**RE: EPC SF2219 – Mayberry Filing 3 CDs Comment Response**

The intent of this letter is to give a broad overview of changes between the most recent Filing 3 Construction Documents submission and the 3<sup>rd</sup> submission. Responses to individual comments can be found on the marked up PDF following this letter. A broad overview of the changes are as follows:

# CONSTRUCTION DOCUMENTS MAYBERRY, COLORADO - FILING NO. 3

NO. **C8.13**

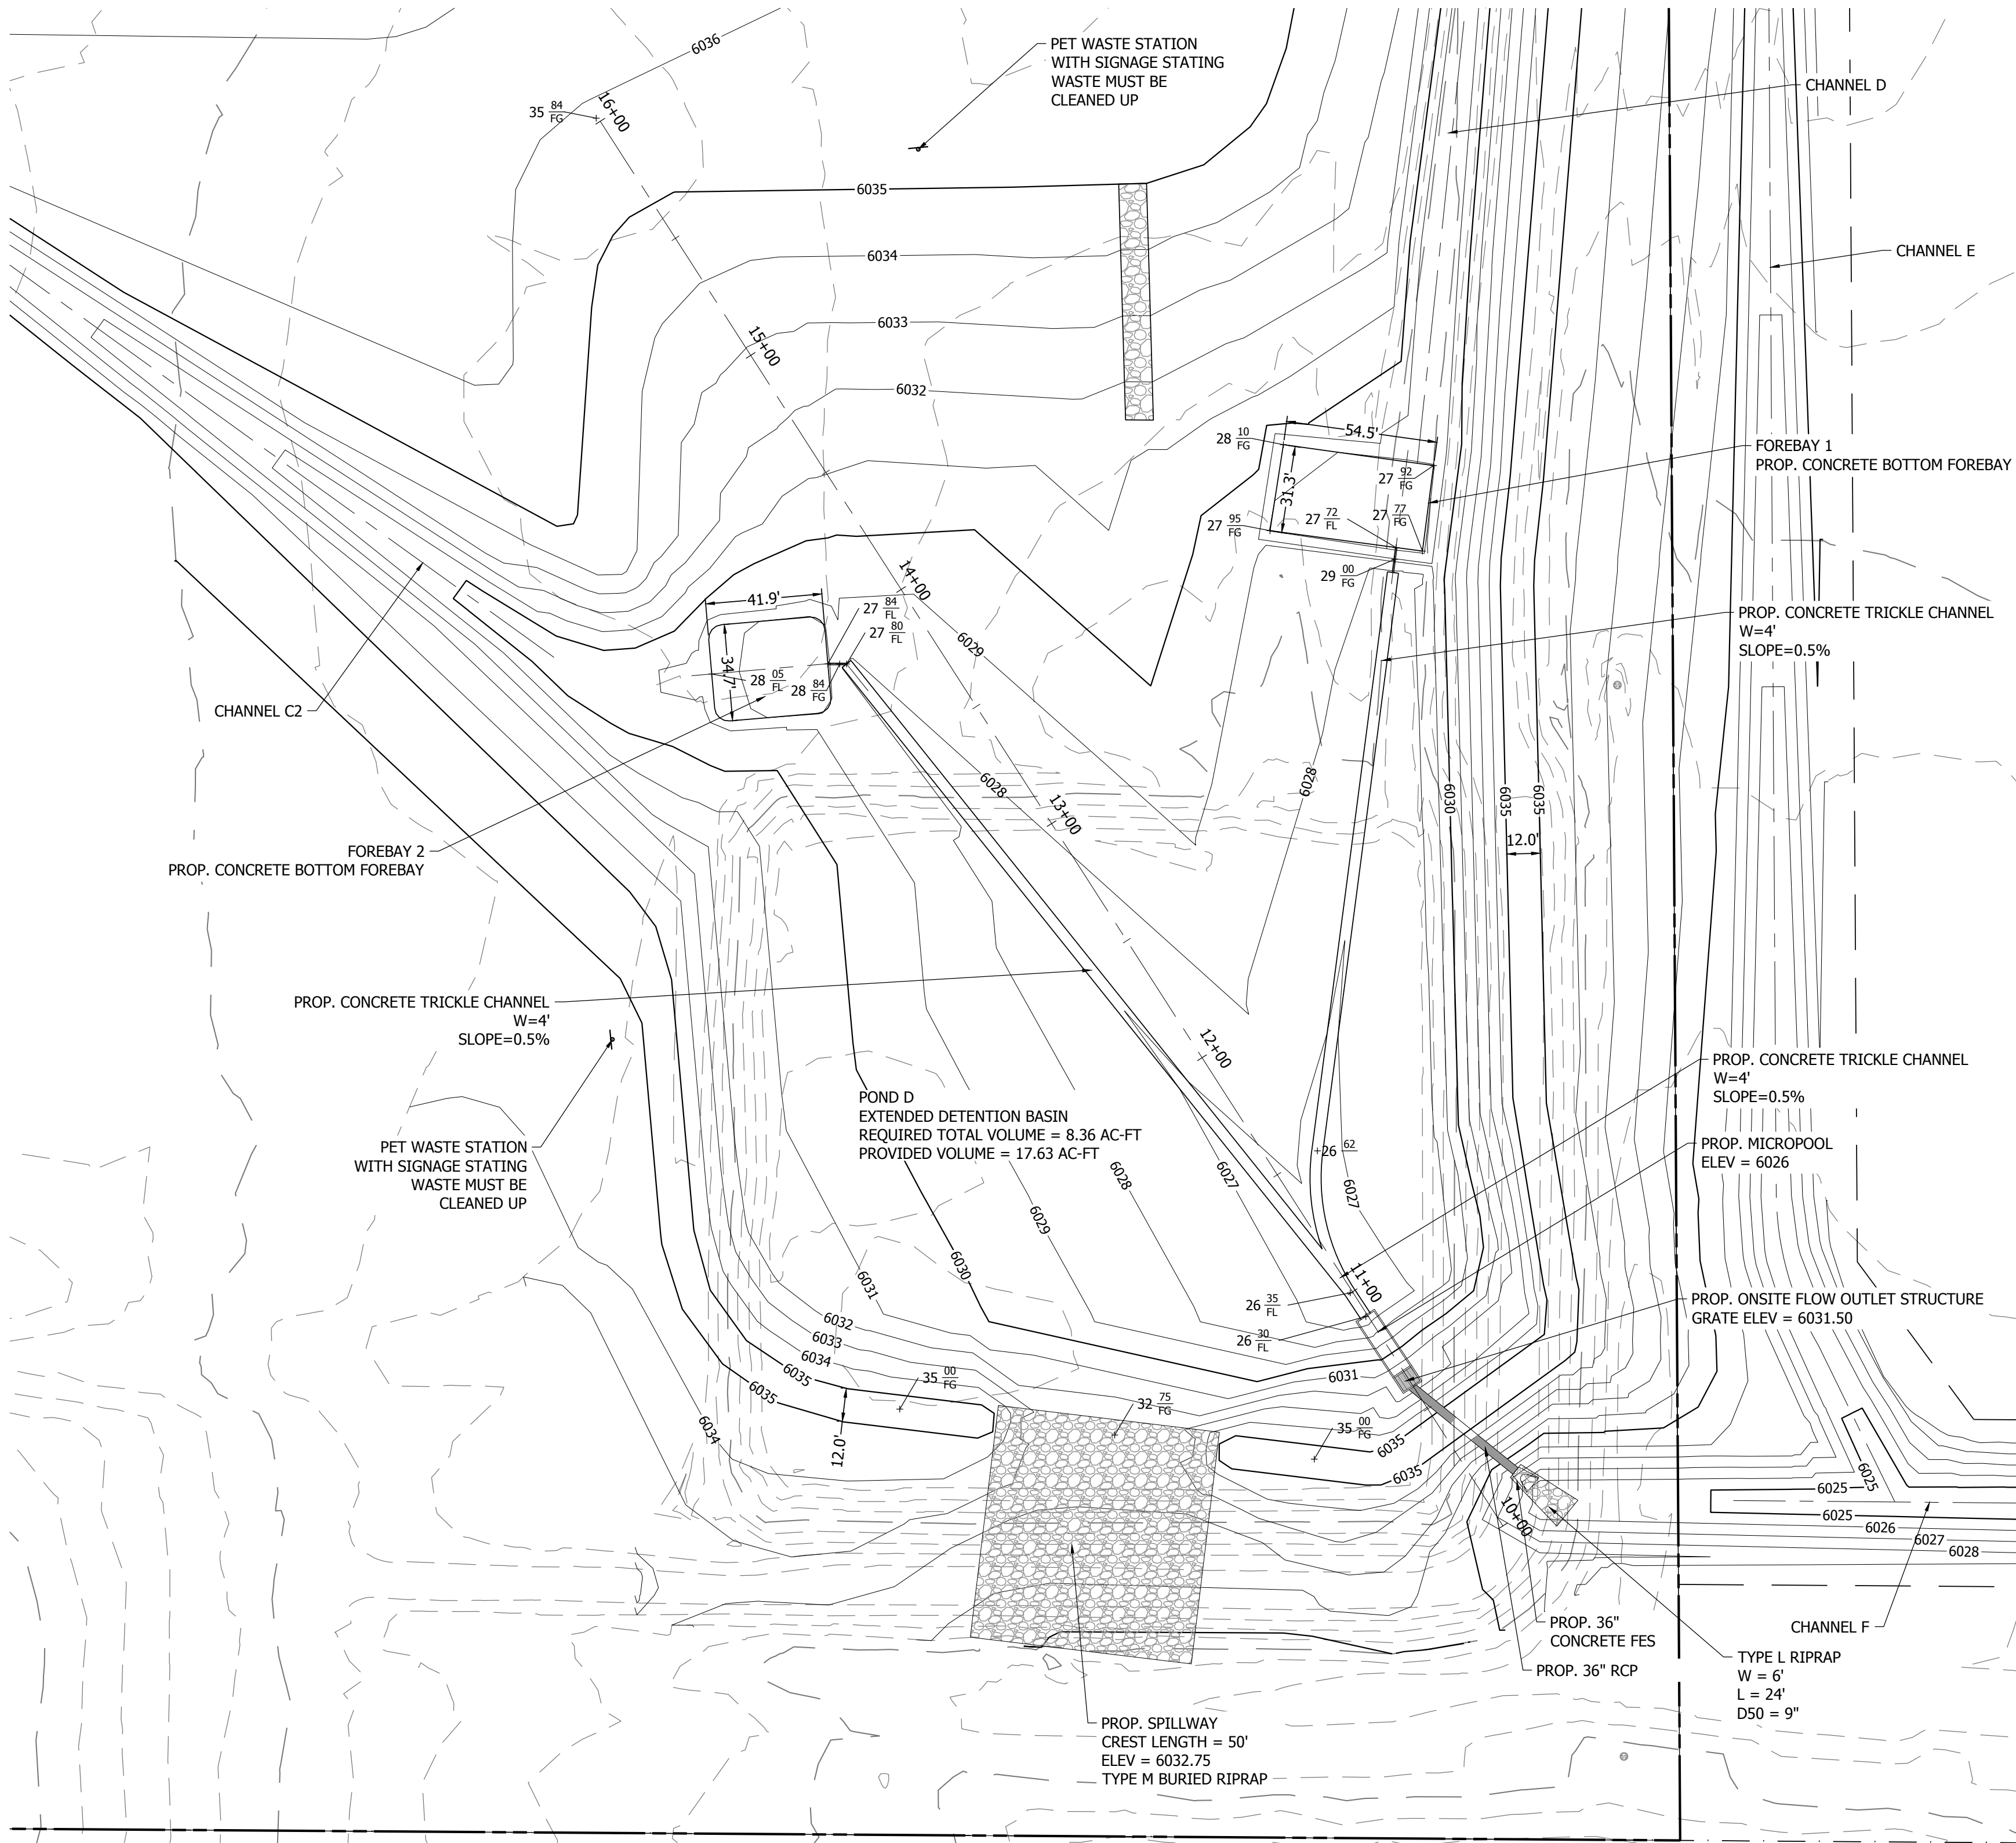
Provide construction details for the proposed pedestrian bridge and also provide grading for berms, trails and swales in the GEC plan. Also provide a typical detail for the trails proposed.

As agreed in the meeting held on October 20, 2022, it was agreed that final details for the bridge can be submitted as a separate permit review but the cross section relative to the 100-year WSE has been provided in the GEC plans on sheet C8.13 as well as the trail and berm details.

NO. **C3.1**

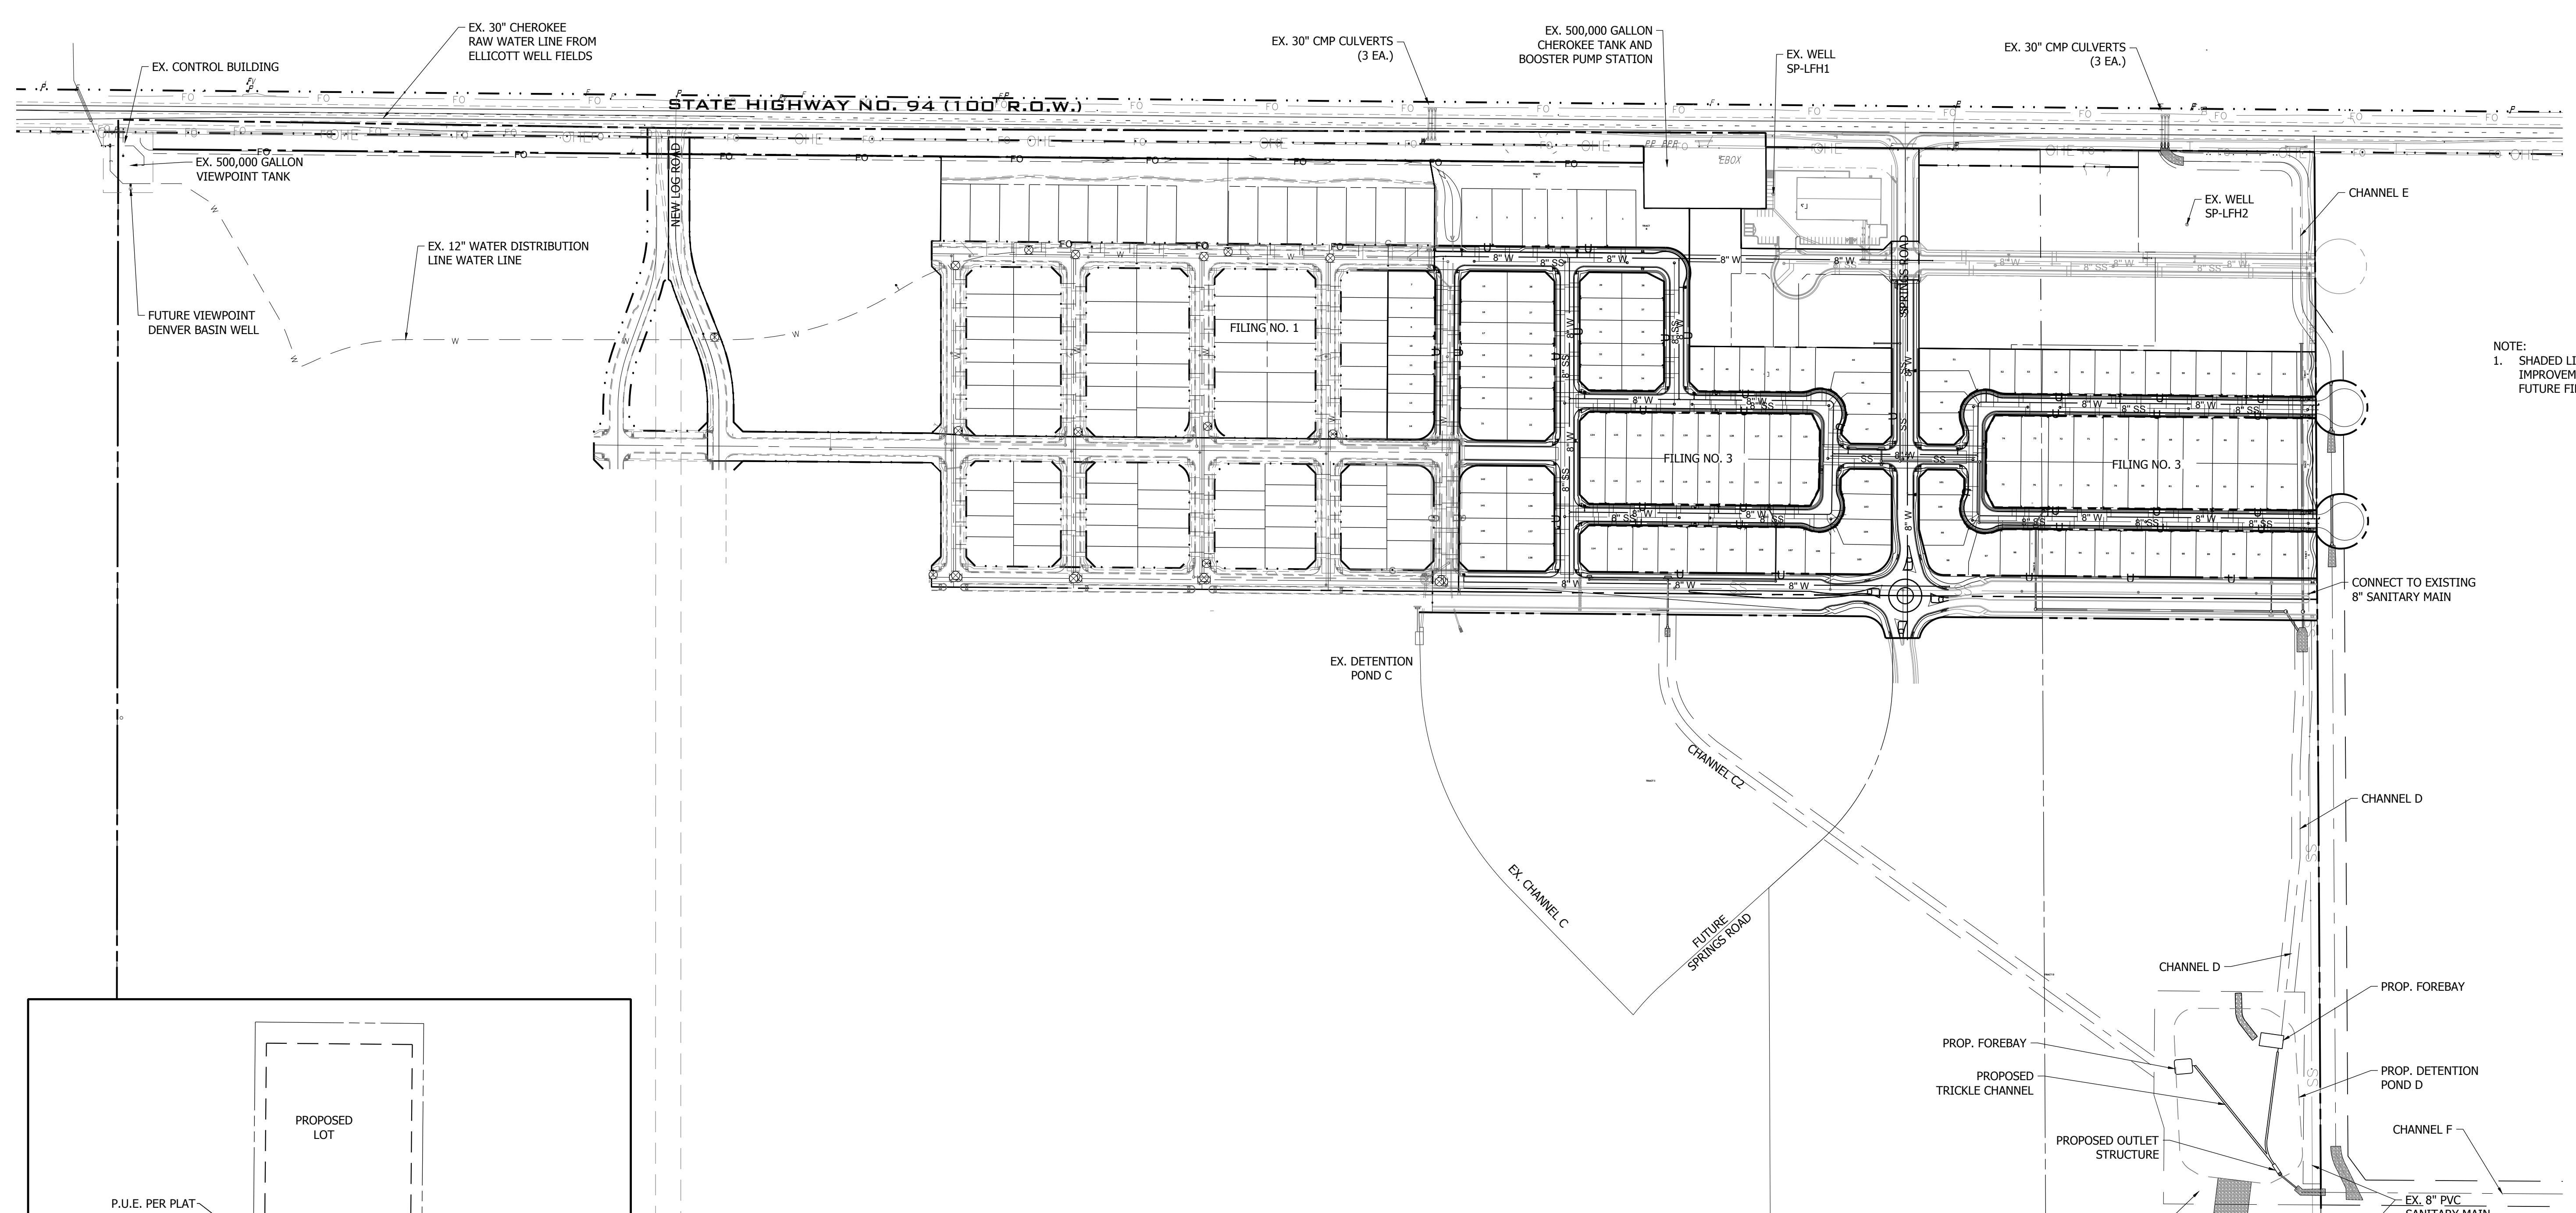
A note has been added. Please provide a note as done on the previous page that the shaded line work to be done with a future filing

**SITE & UTILITY PLAN - WEST**

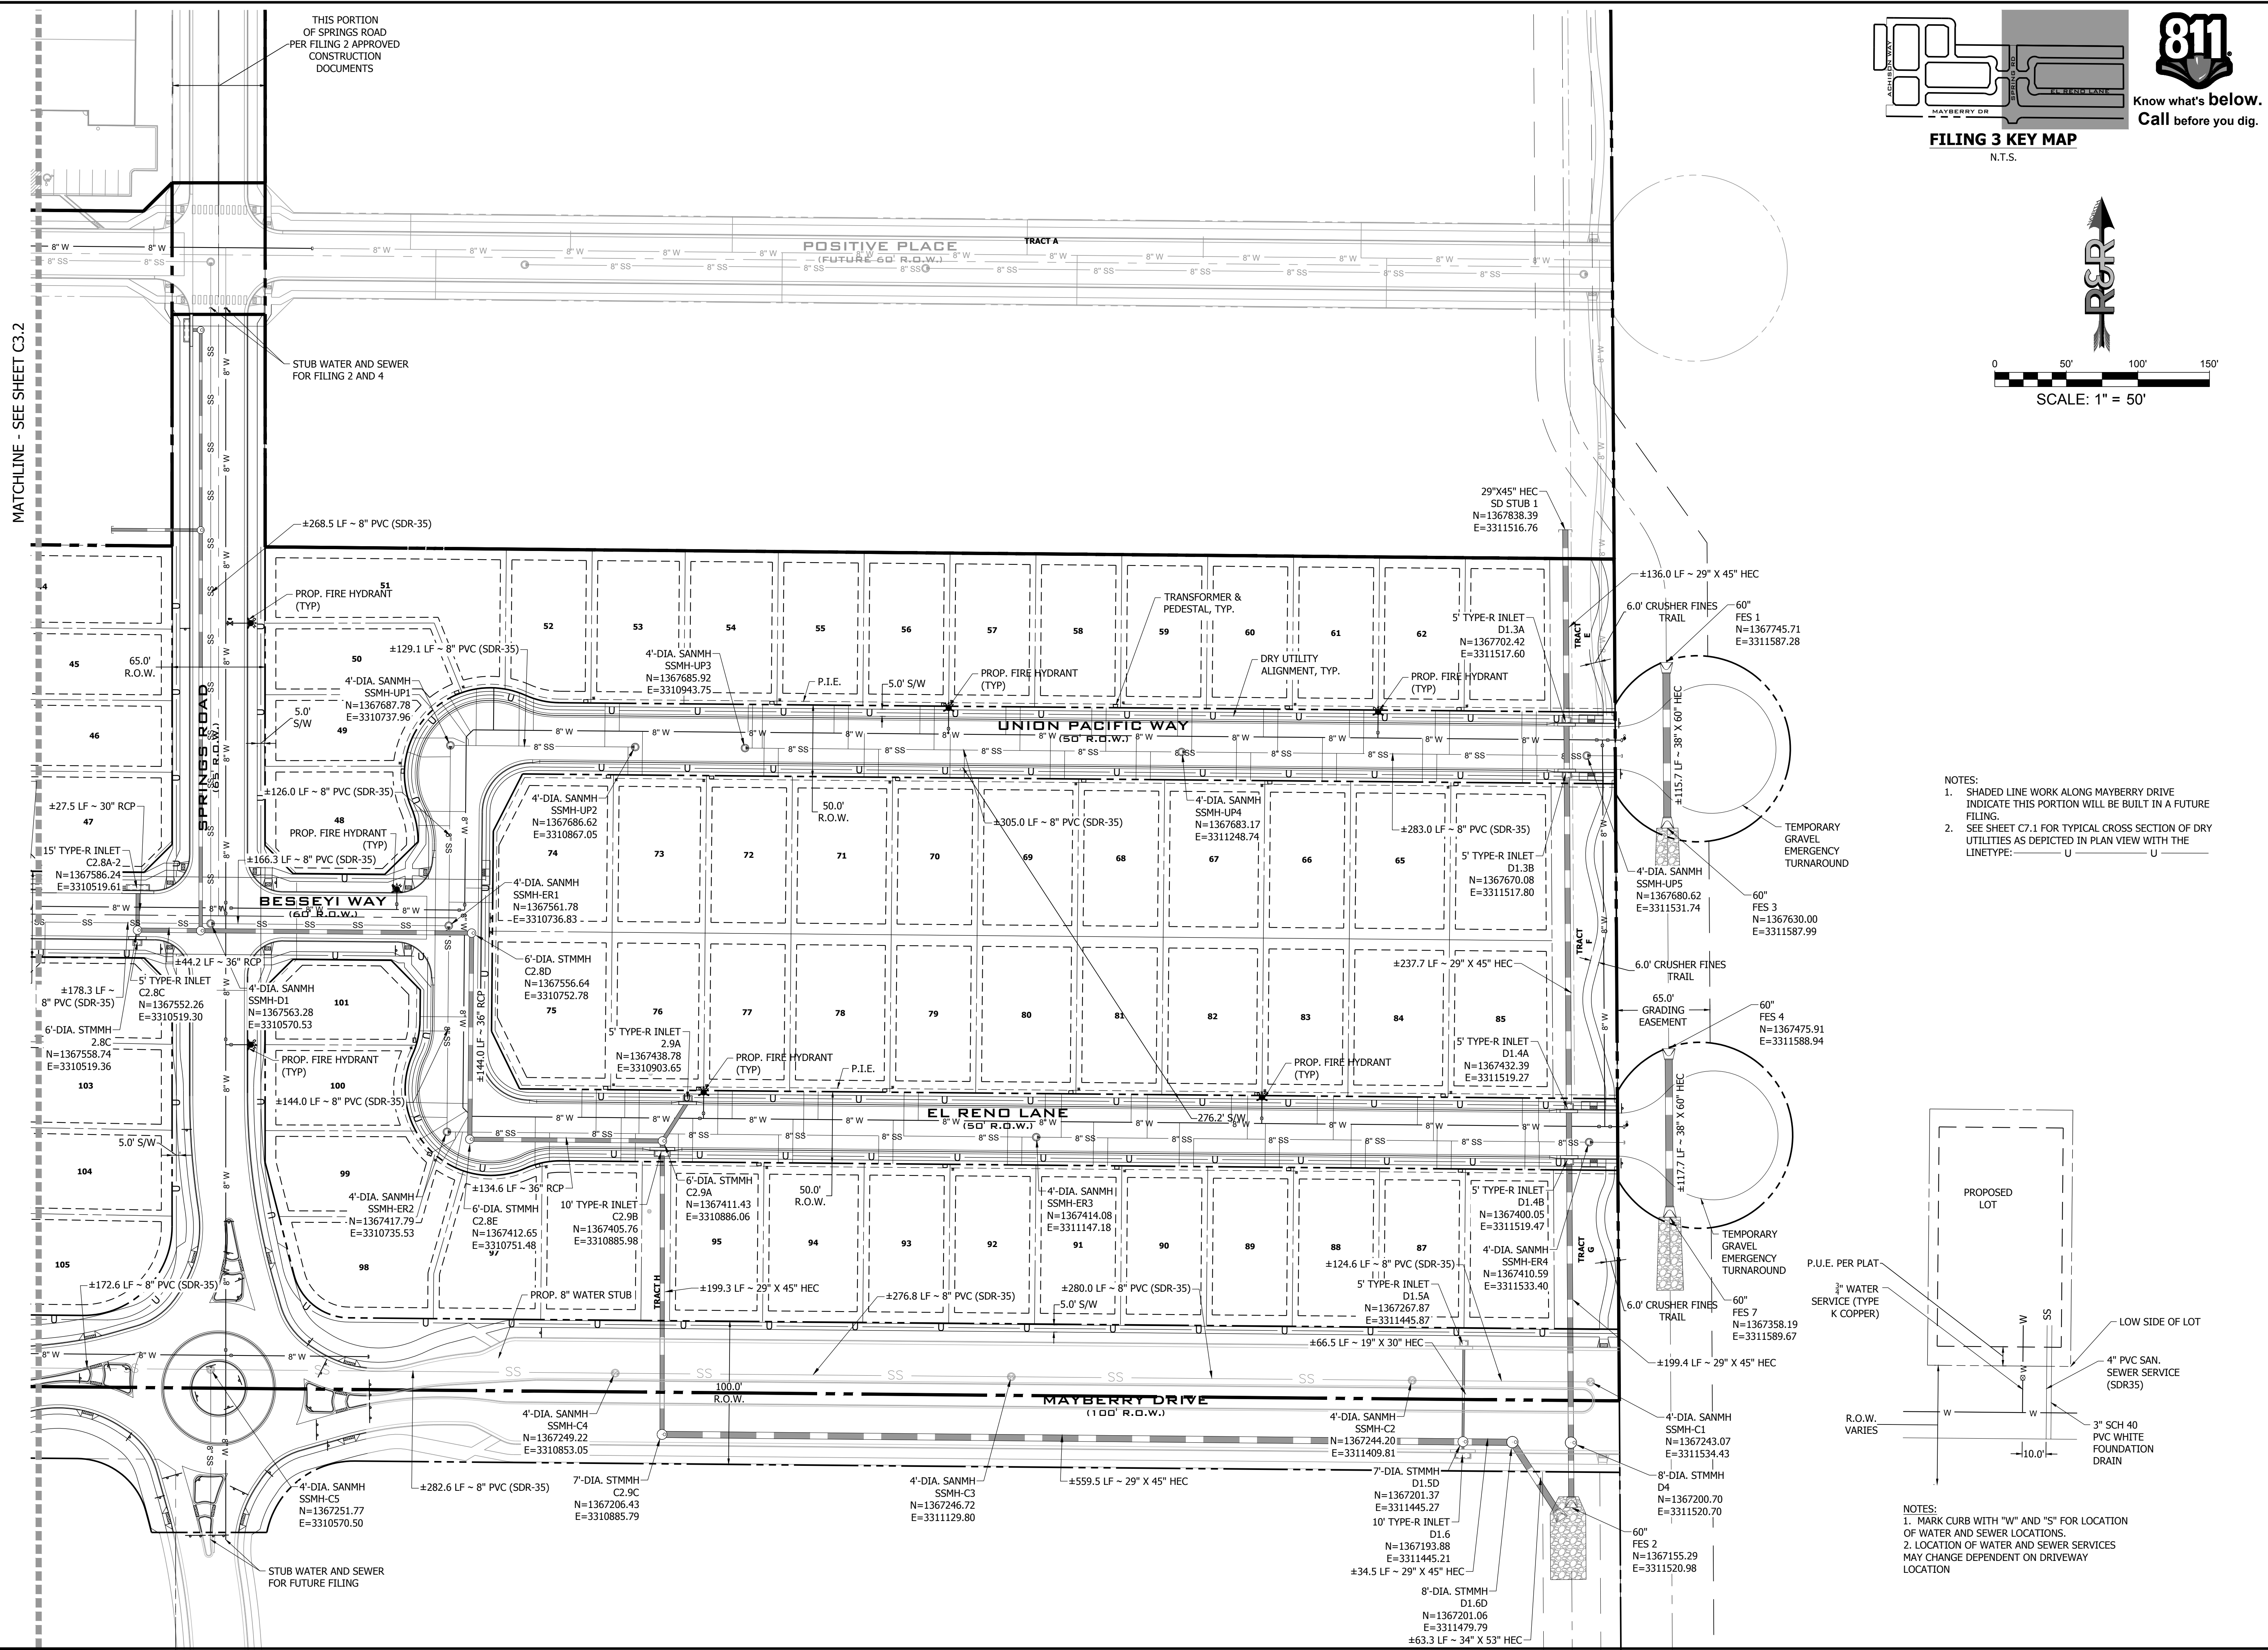
Filing 2 CD's identified that Springs Rd would be constructed (to full standard section) from Hwy 94 to Cattlemen Run. Please include construction of this portion as part of these CD's

Unresolved. What material is being used for the trail?

Show these temporary turnaround easements on plat.

a 10' inlet is identified on the calculations. Revise accordingly. Verify that all inlets in the CD's match what is designed in the calculations

Please provide note that the shaded line work indicates that it will be built with a future filing.

This portion of Springs Road is now included in the Filing 3 limits.

This trail will be crusher fines and is now labeled on the plan. A detail of its cross section has been added to the GEC plans.

Temporary turnaround easements are now shown on plat.

Inlet size has been verified with drainage report.

A note has been added on the right side of this and the previous sheet.
